**Consultation Response from KC,
Highways Development Management****2023/91887 Adj, 5, Fernside Avenue, Almondbury, Huddersfield, HD5 8NR****Demolition of existing building and erection of two dwellings****Date Responded: 20/09/2023.****Responding Officer: D. Stainsby****Responding Ref:**

This application is for the Demolition of an existing builders' store/depot and erection of two terraced dwellings.

Drawing title
Proposed Site Block Plan

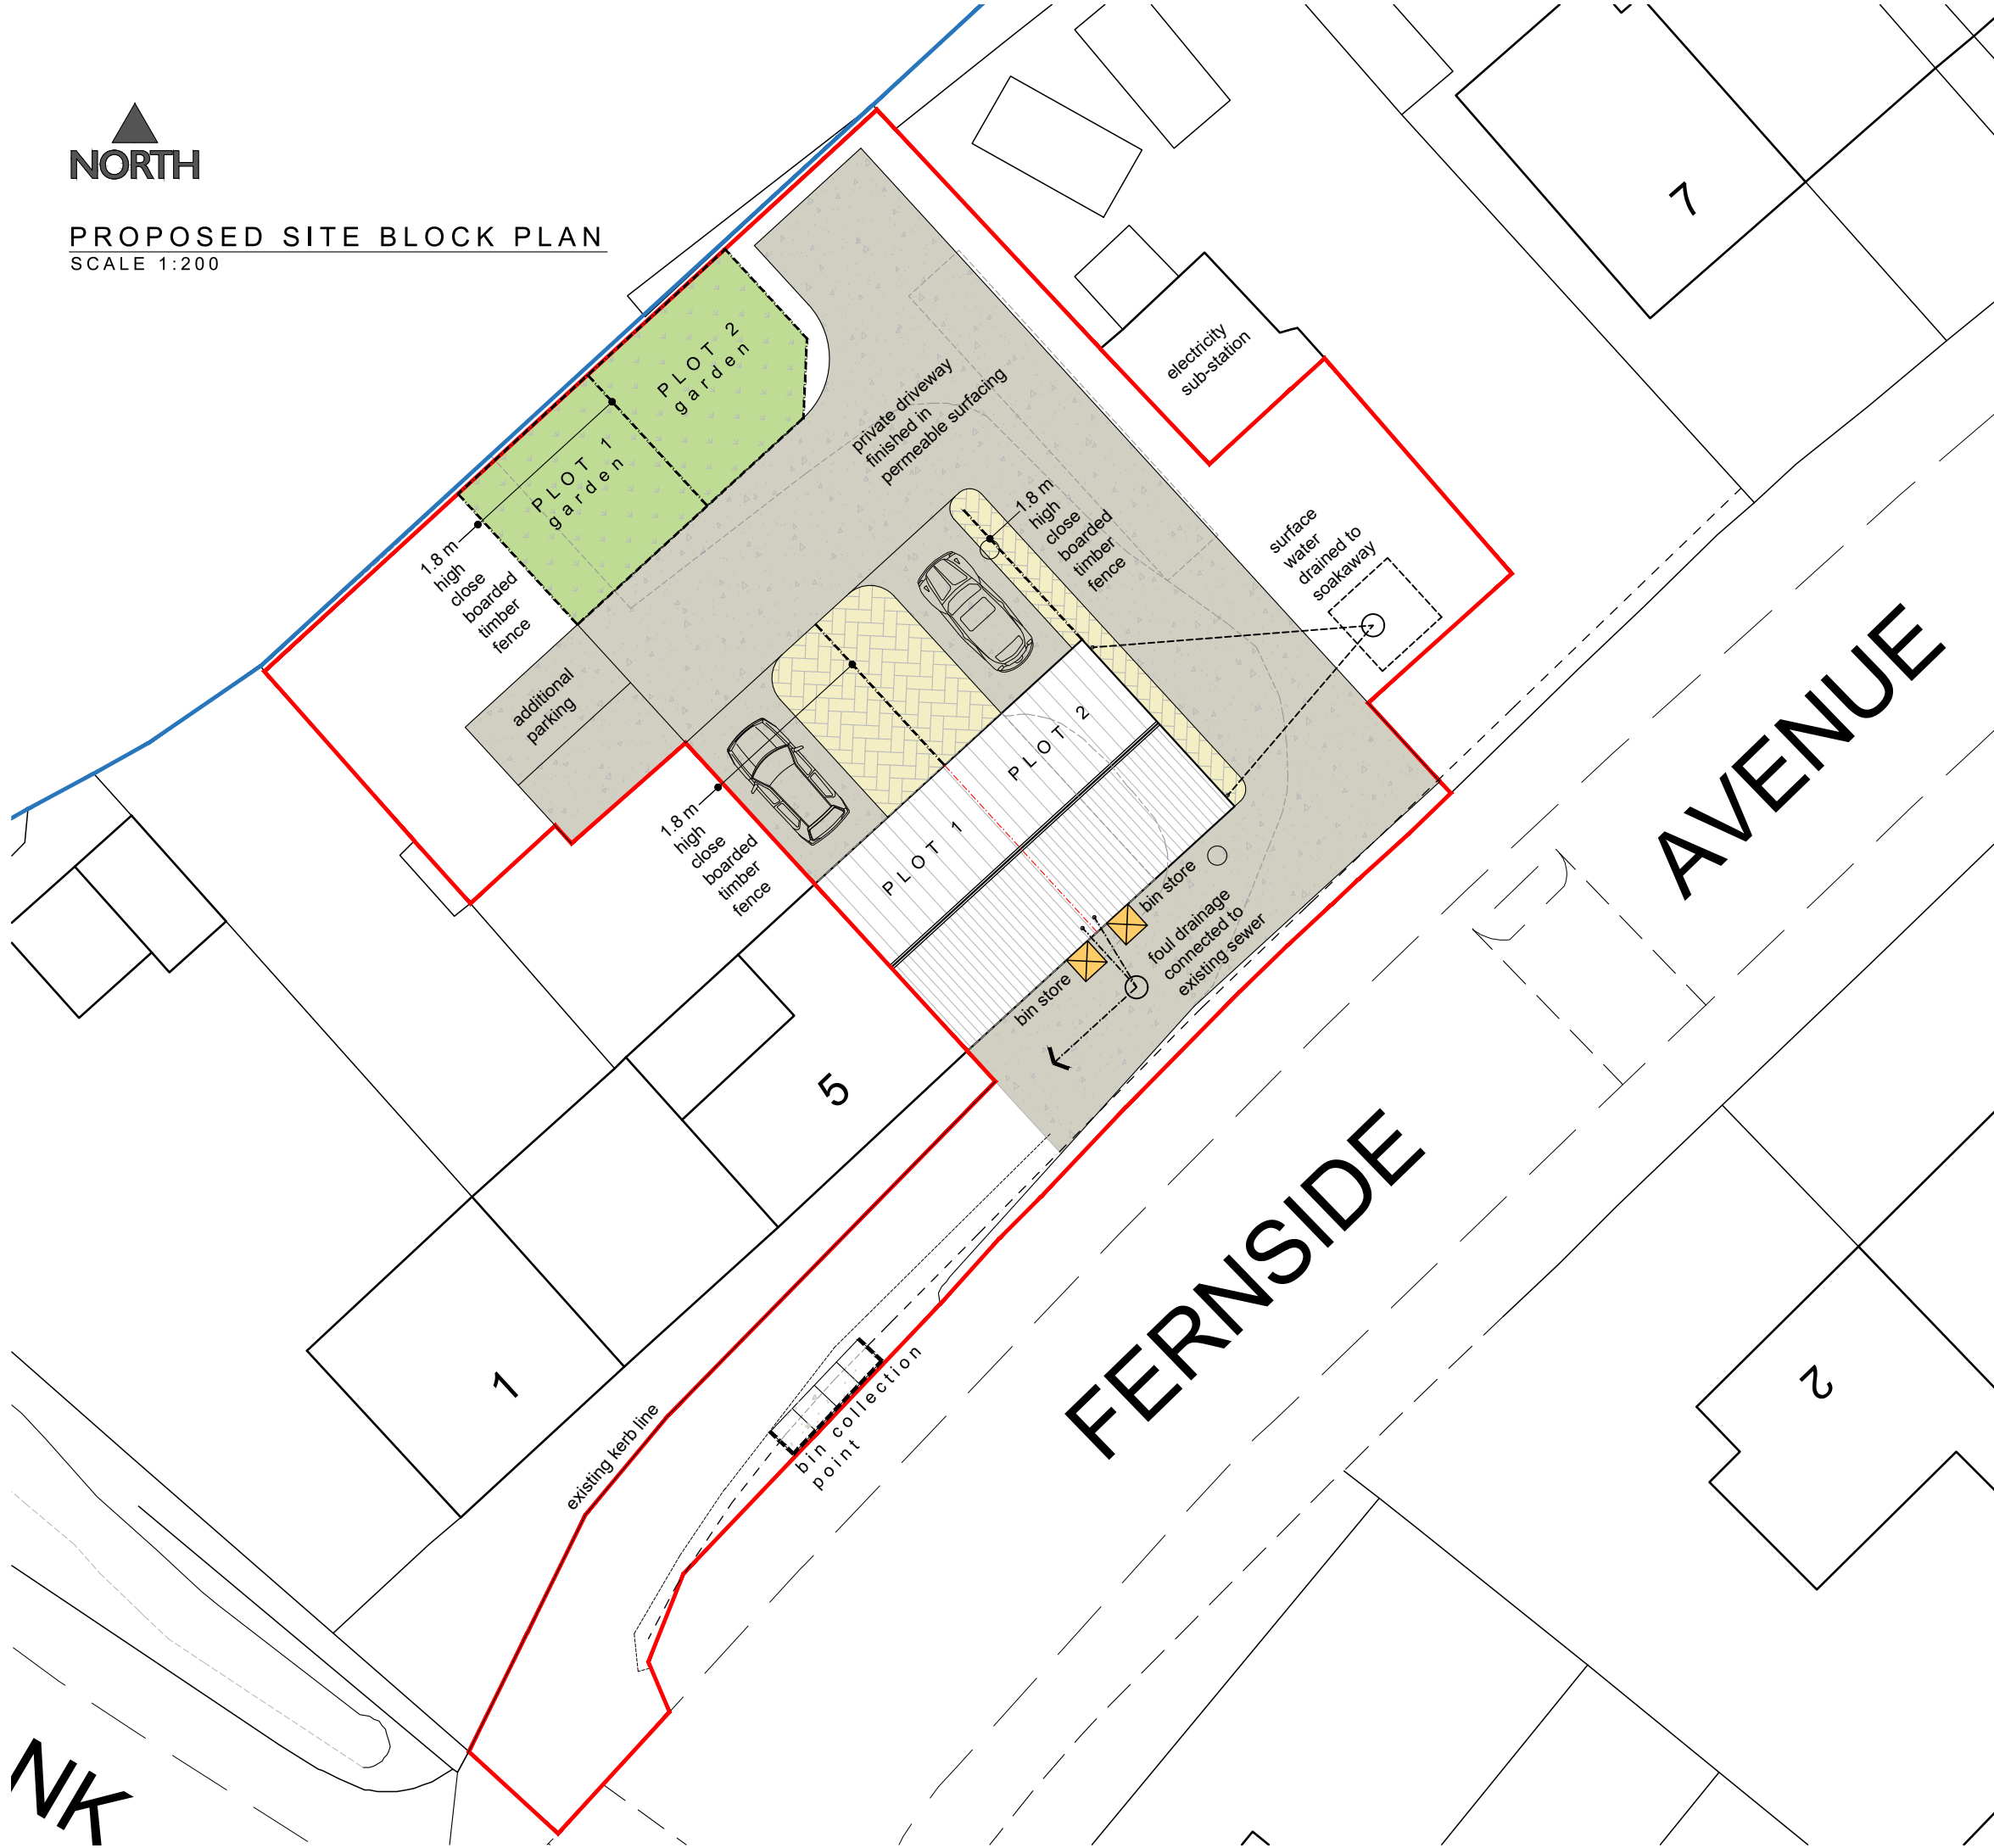
A Bin storage area has been provided which is acceptable. However, this is over the minimum carry distance for the refuse collectors and as such a bin collection/presentation point should be located adjacent to the public highway.

Details of the waste collection/presentation point should be provided, with the location being clearly marked on a drawing in such a location that is easily accessible to the collection team and where it will not obstruct the access or the adopted highway for road safety reasons.
